Approval of details reserved by condition under AL/31/22/PL relating to conditions 5- Surface Water Drainage, 6- Drainage System to Adjacent Land and 7- Maintenance and Management of Surface Water Drainage System.

Land West Of Ryefield Farmhouse Oak Tree Lane Woodgate PO20 3GU

Arun District Council have decided to **REFUSE details reserved by condition for the following reasons:**

Drawing Title
Geotechnical Investigation Plan

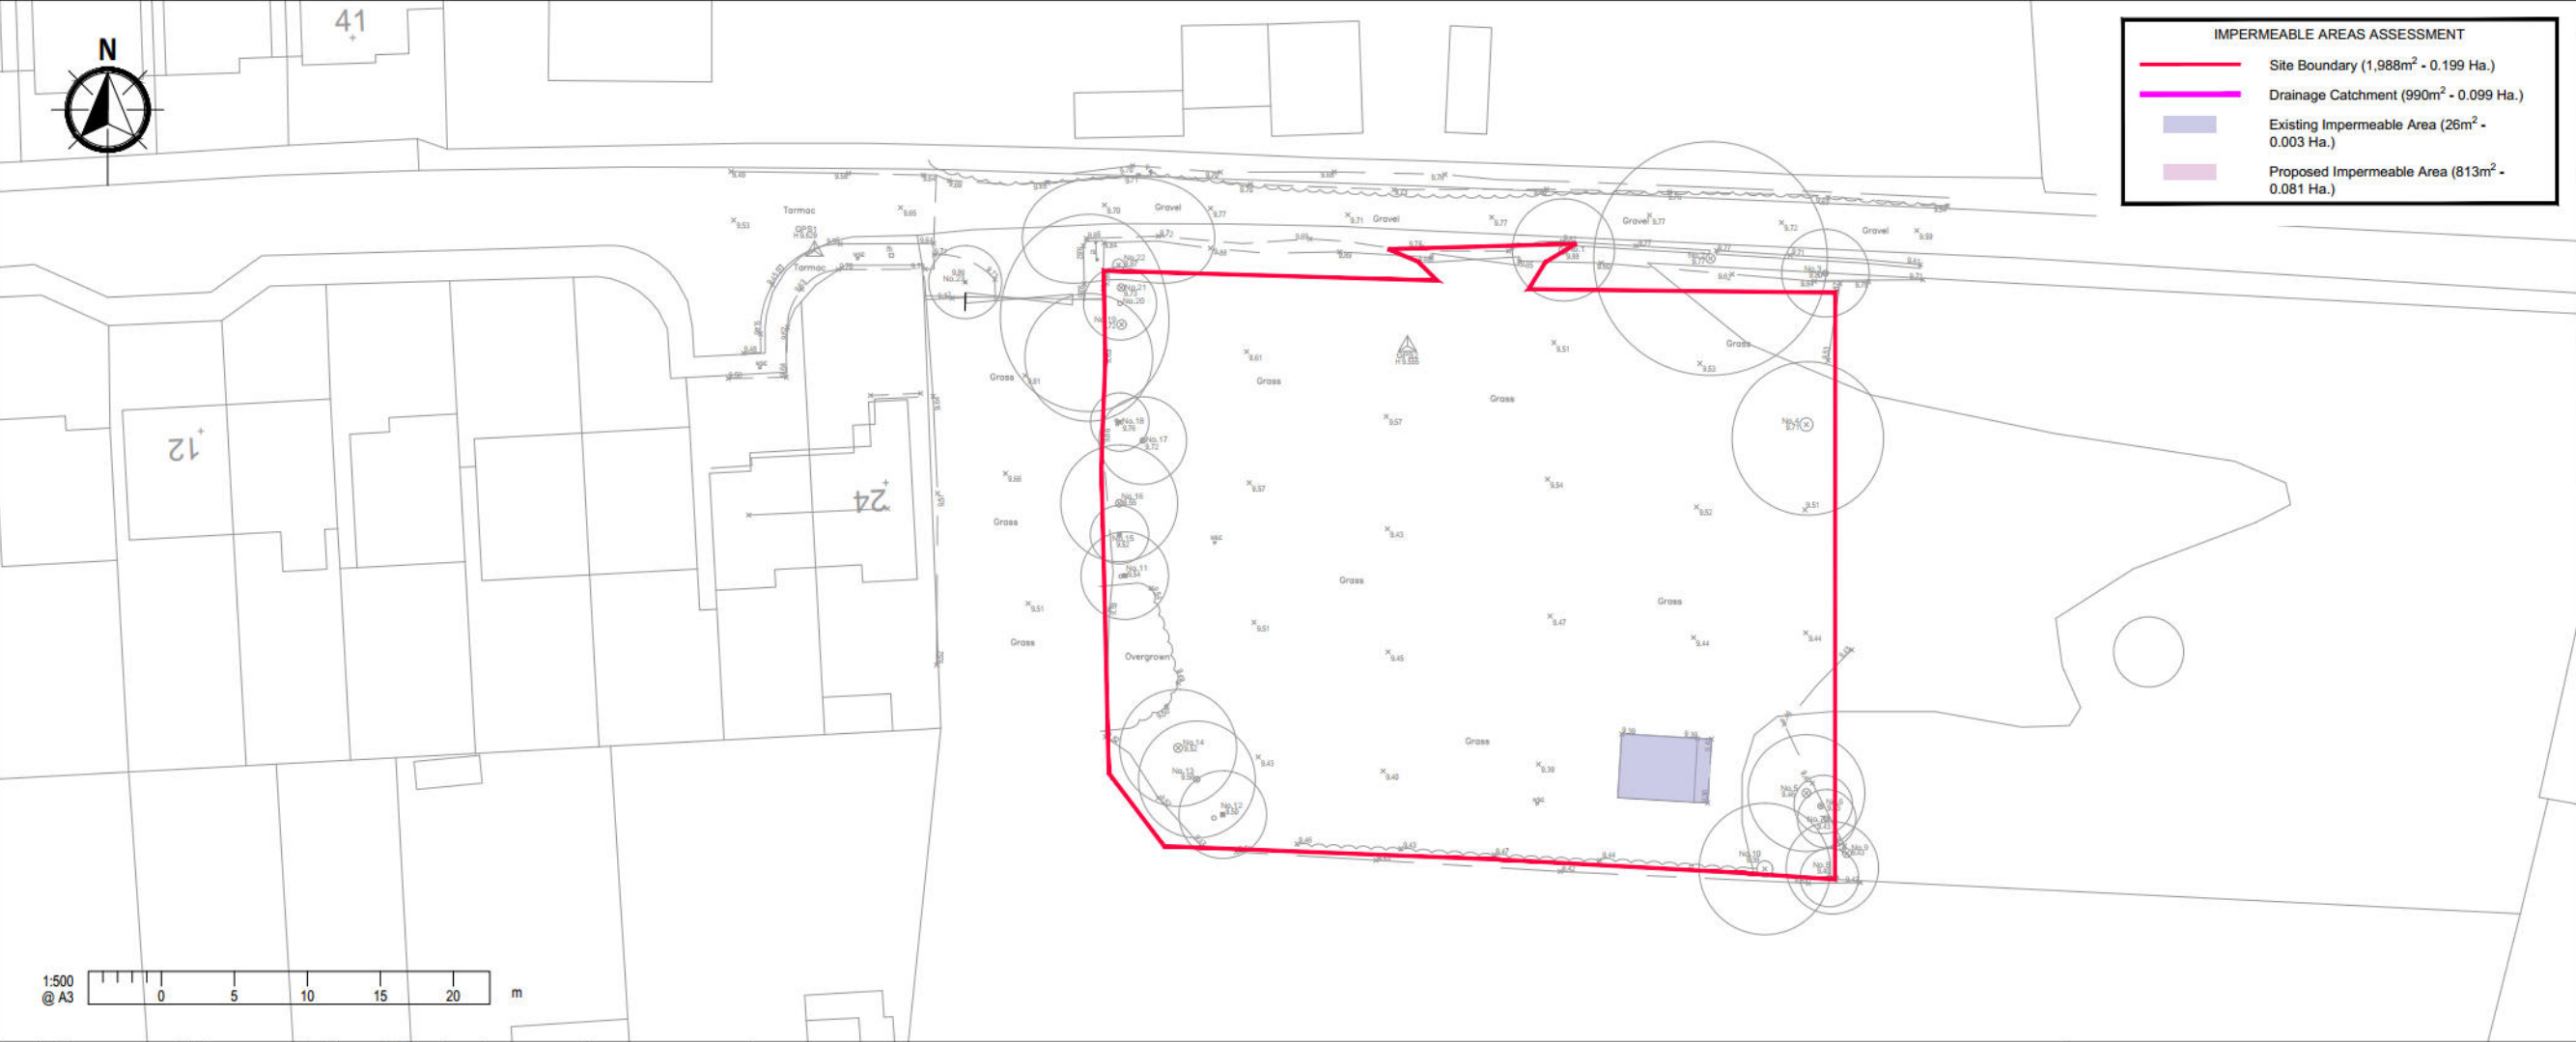
The proposed surface water drainage design relies on a temporary discharge to the public foul sewer, contrary to national and local drainage policy and guidance, including the National Standards for Sustainable Drainage Systems (NSfS). It proposes to connect to surface water infrastructure associated with the adjacent Woodgate Centre development (AL/107/21/PL) once that infrastructure has been delivered.

The site lies within the Lidsey Wastewater Treatment Catchment Area, where a Surface Water Management Plan is in place due to historic foul sewer flooding partly caused by surface water inundation. Any discharge of surface water to the foul sewer, even temporarily, is unacceptable as it risks increasing flood risk, pollution, and contamination from sewer flooding.

The proposed drainage design does not demonstrate compliance with the surface water drainage hierarchy set out in Approved Document H of the Building Regulations, the CIRIA SuDS Manual, and the National Standards for Sustainable Drainage Systems (NSfS).

This conclusion is reached because a watercourse is located approximately 350 metres east of the site, yet the submission states that no watercourse outfall is available and provides no detailed assessment of this option before proposing discharge to the foul sewer.
